August 21, 2025

Reference: Engineering Services
181 Rad Street
Lillington, NC 27546
TE&D Project No.: 2501-020663

As requested, a representative of Tyndall Engineering & Design, PA (TE&D) was on-site to observe the following item(s):

First Floor Plan

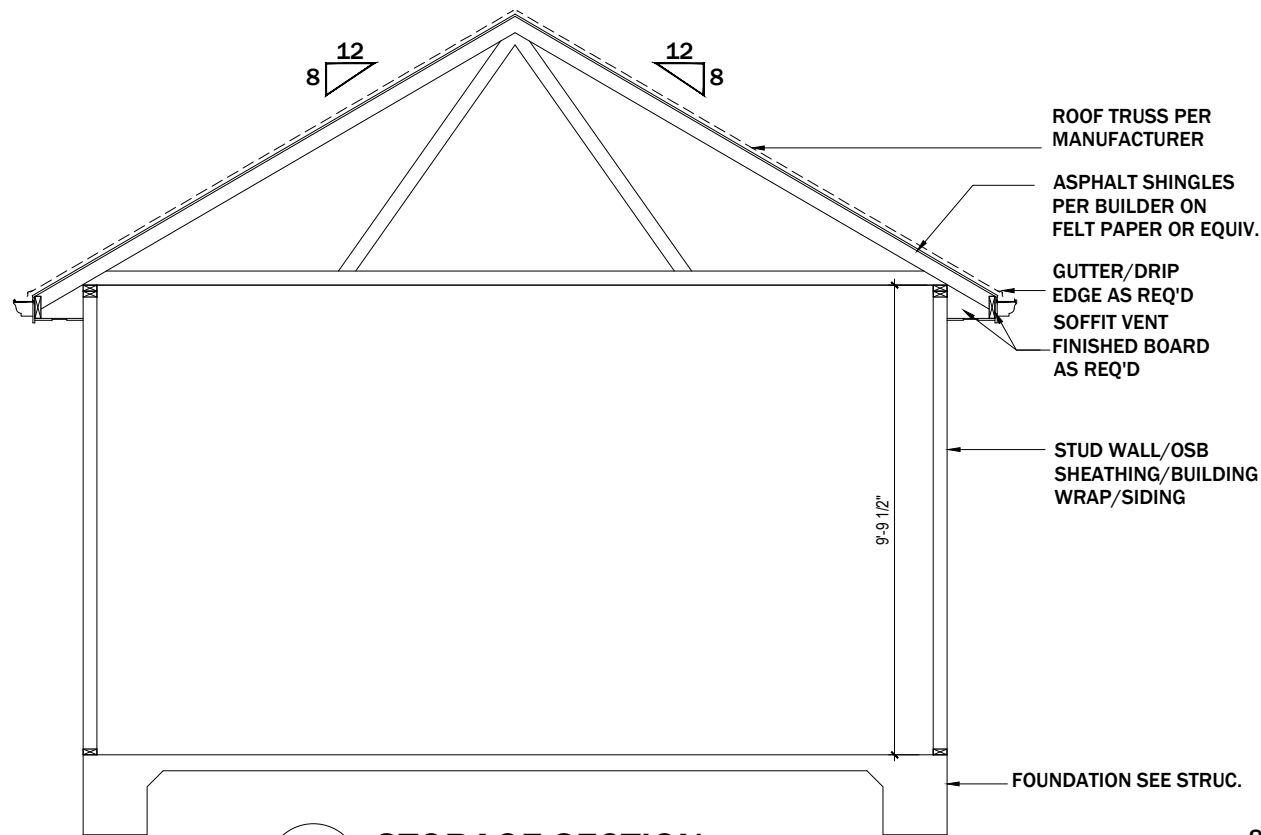
- 1) 18' garage door opening on the left side of the garage in-lieu of the plan specified 9' opening. (All Views facing the garage from the driveway.

- 1) Based on our observations and analysis, the existing 18' garage door opening supported by a (3) 1-3/4" x 24" LVL header will adequately support the anticipated loading conditions.
